From: Zac Denton <Zac.Denton@arun.gov.uk>
Sent: 02 December 2020 08:36
To: Planning.Responses <Planning.Responses@arun.gov.uk>
Subject: FW: Mistletoe Cottage, Climping - CM/46/20/HH

From: BRYAN BUTCHER [REDACTED]
Sent: 30 November 2020 19:42
To: Zac Denton <Zac.Denton@arun.gov.uk>
Subject: Mistletoe Cottage, Climping - CM/46/20/HH

BLOCK PLAN 1/500

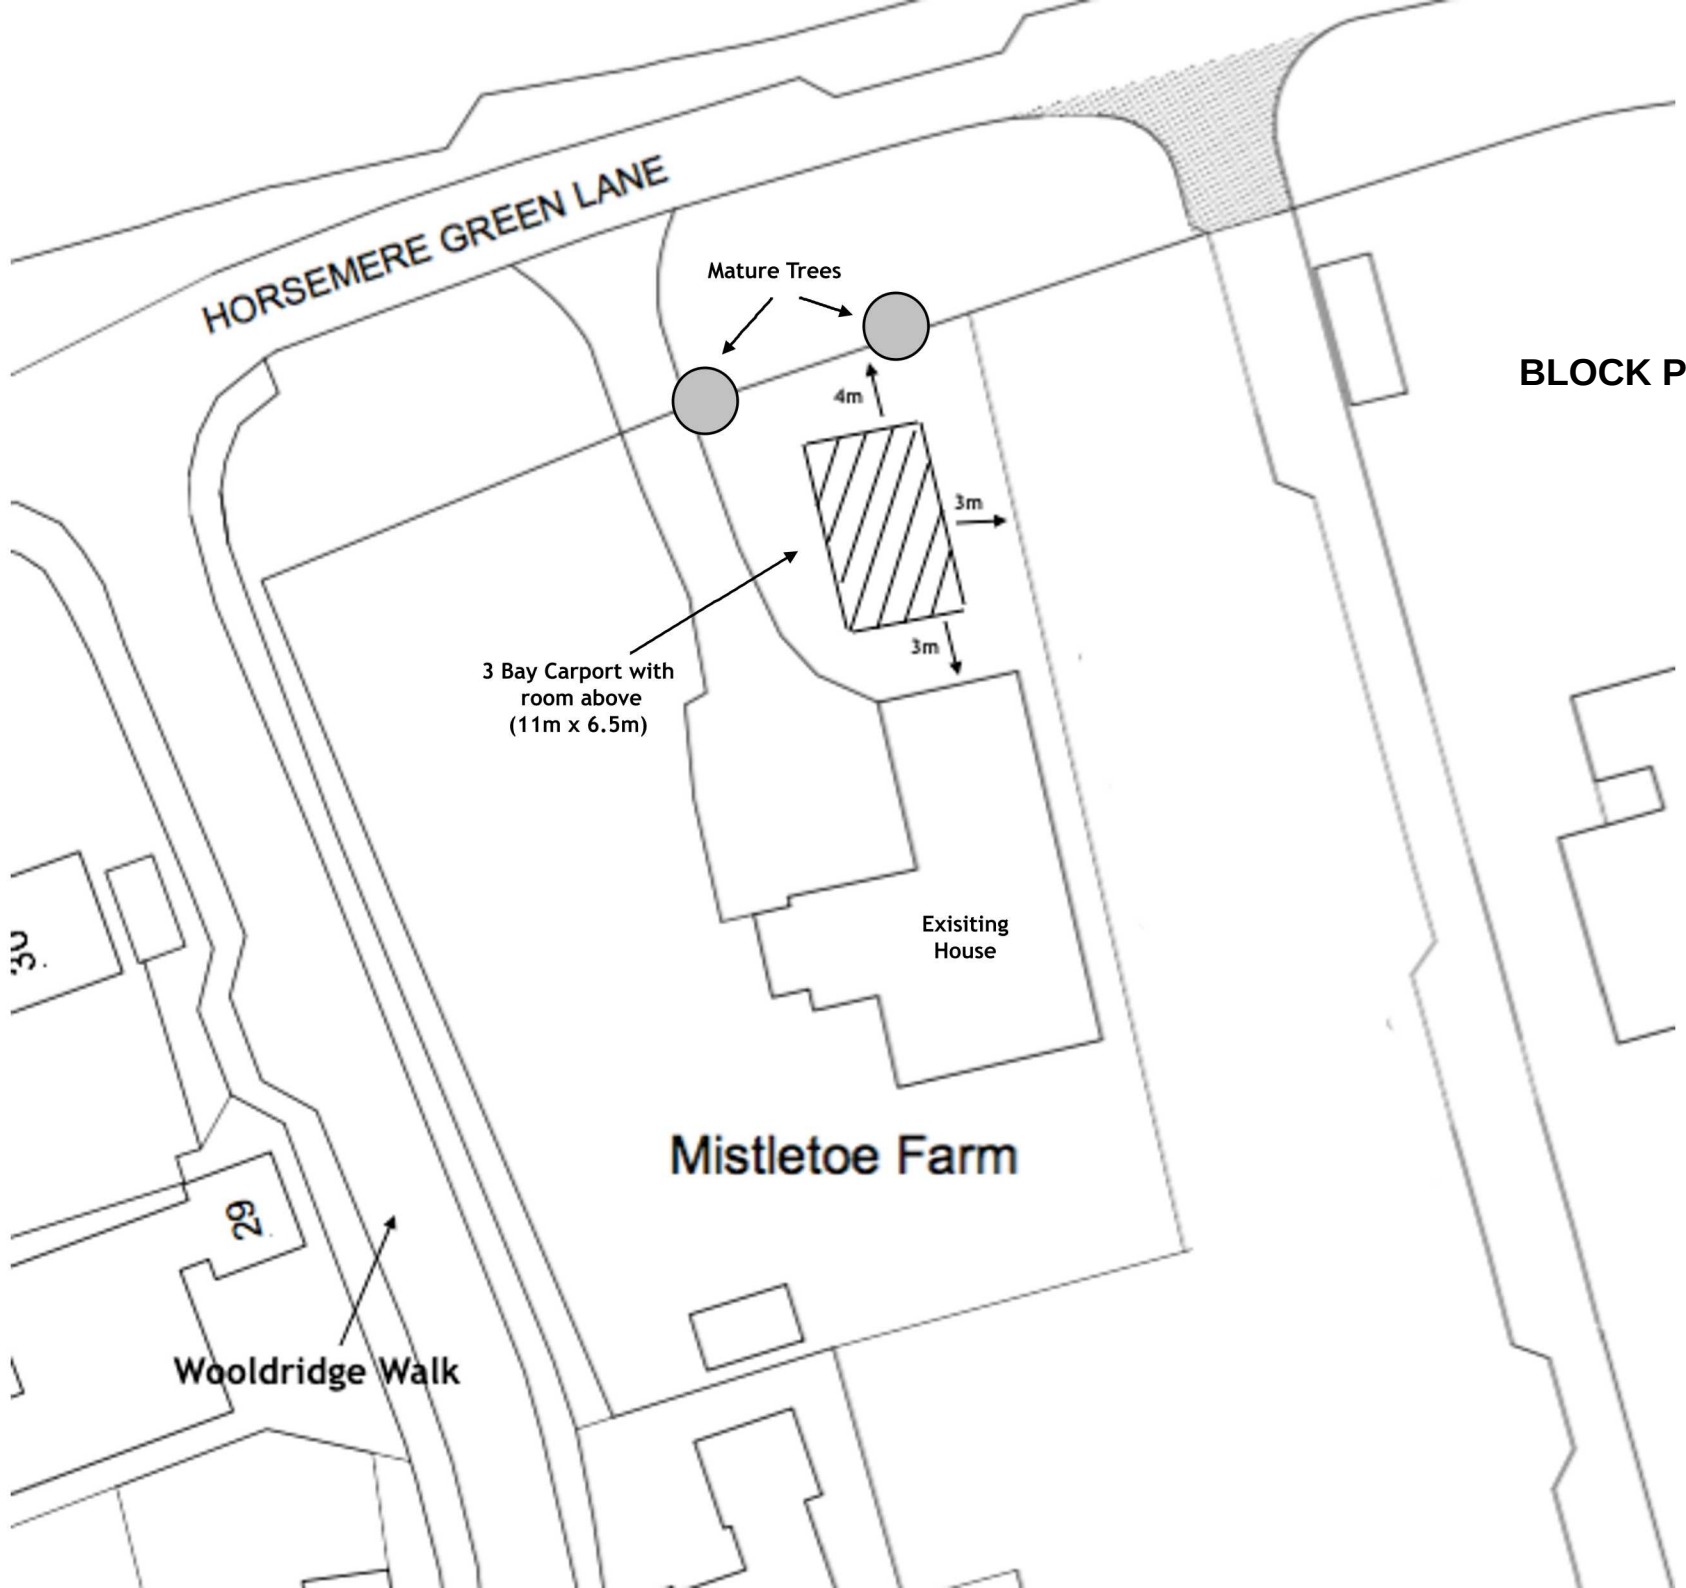
I was surprised to see the huge inaccuracy of the submitted 'red edge' as I can confirm that the Applicant does in fact not own all the land suggested on the plan.

If my memory serves me correct there is also a rather splendid English Oak tree at the front of Mistletoe Cottage which appears to be missing from the plans unless it has been removed.

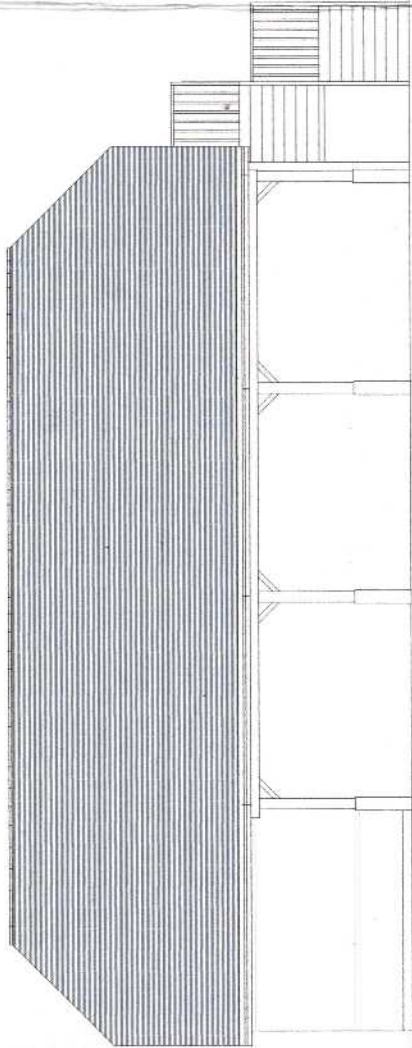
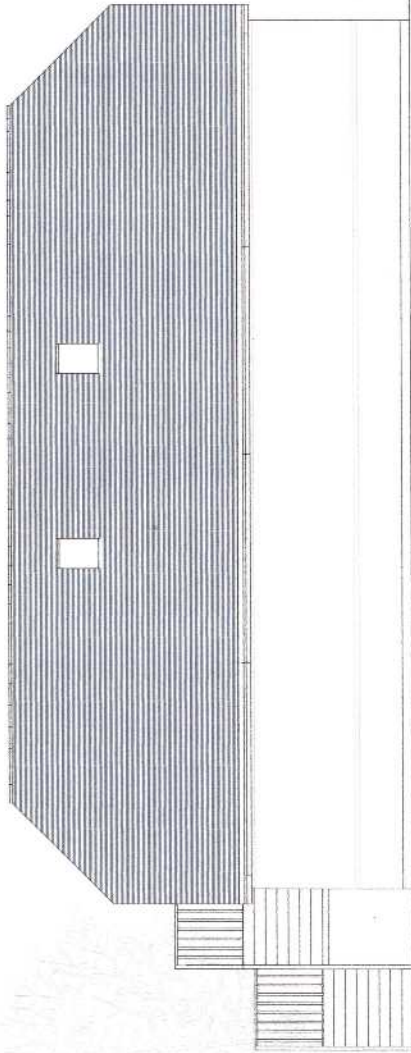
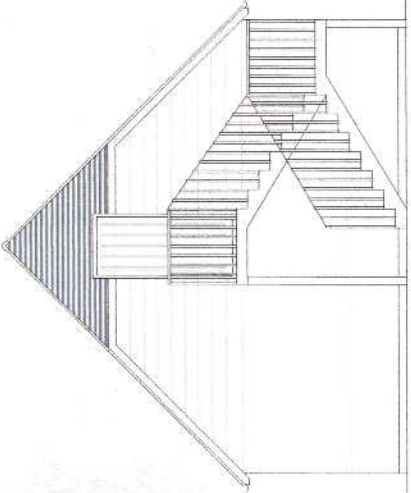
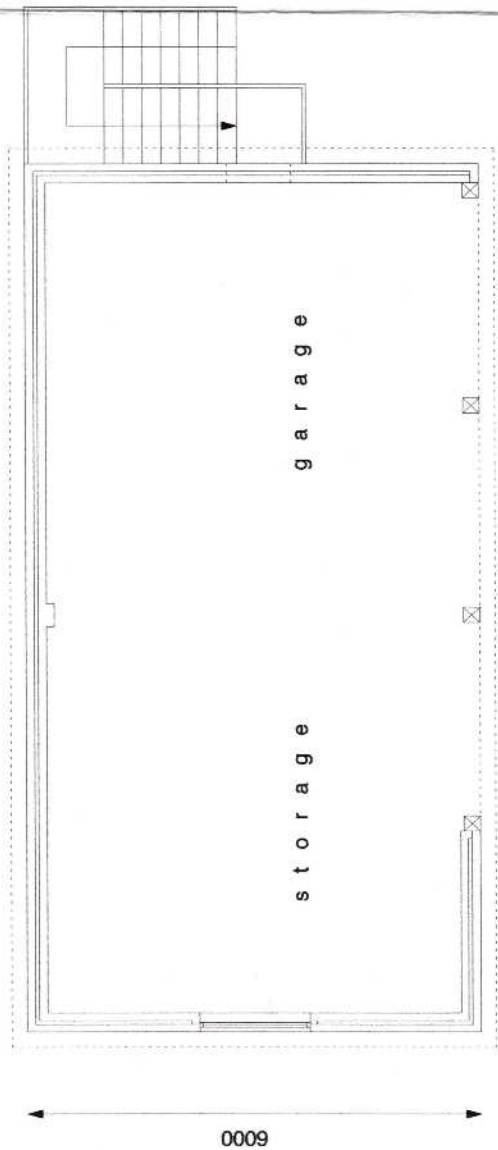
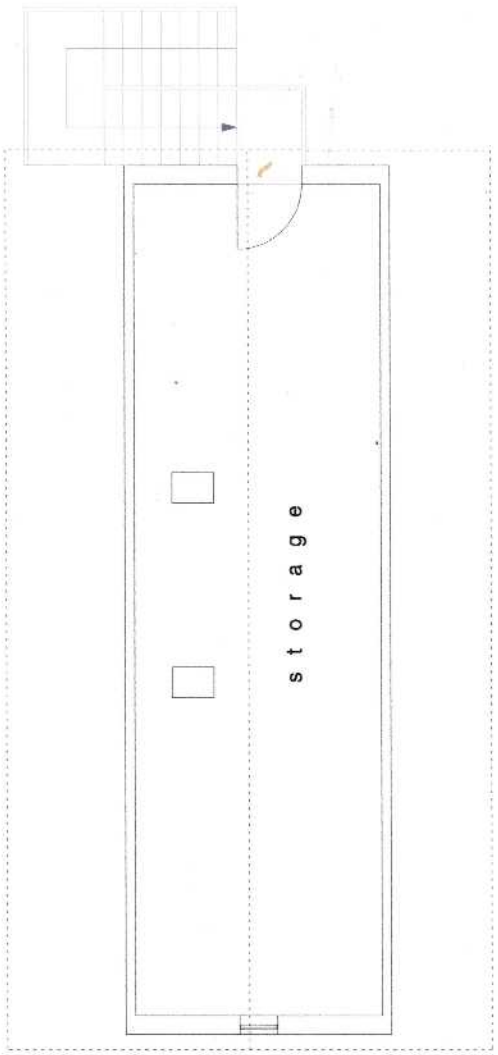
I note that the plans and the application forms differ in the form of the applicant's initial [Plan shows a B where the applicant is a J] although this is likely to be another family member or clerical error.

The plans themselves are dated 2006 and drawn by a previous Agent so I hope no copyright issues have been crossed as I like to try and look after other Agents as they look out for me.

In passing the proposal appears to be truly awful in terms of size, position and mass as well as the inclusion of an unneighbourly external staircase and will be surprised if it receives a permission.
